From: Janice Chapman
Sent: 27 October 2014 13:19
To: Dafydd Lloyd
Subject: RE: FP/168/14/T

MAP Ref: 25432

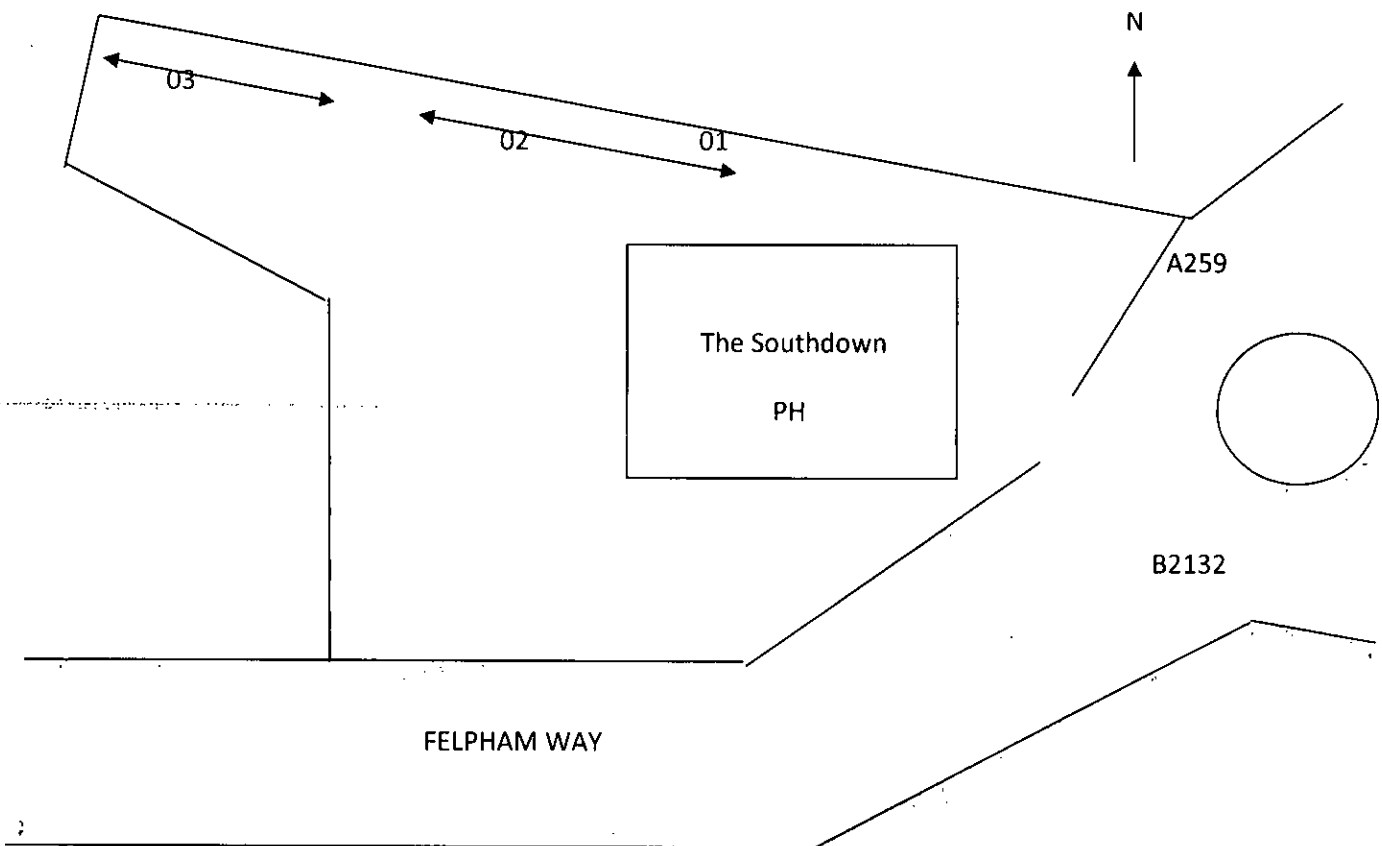
I thought there was just One TPO active on the Hawthorn trees here (TPO/4/62), not one on the conifer hedge line. If the conifer hedge line does have an active TPO the following conditions are to be met:

- 5 or more individuals to be replanted (because of the available space).
- The chosen replanting stock to have an expected mature growth height of 4 meters and higher
- Individuals to be replanted within 5 meters of original existing trees location.

In view of the conifer hedge being removed shall I impose a condition regarding a replacement tree(s).

You are correct the only ones covered are the Hawthorn trees.
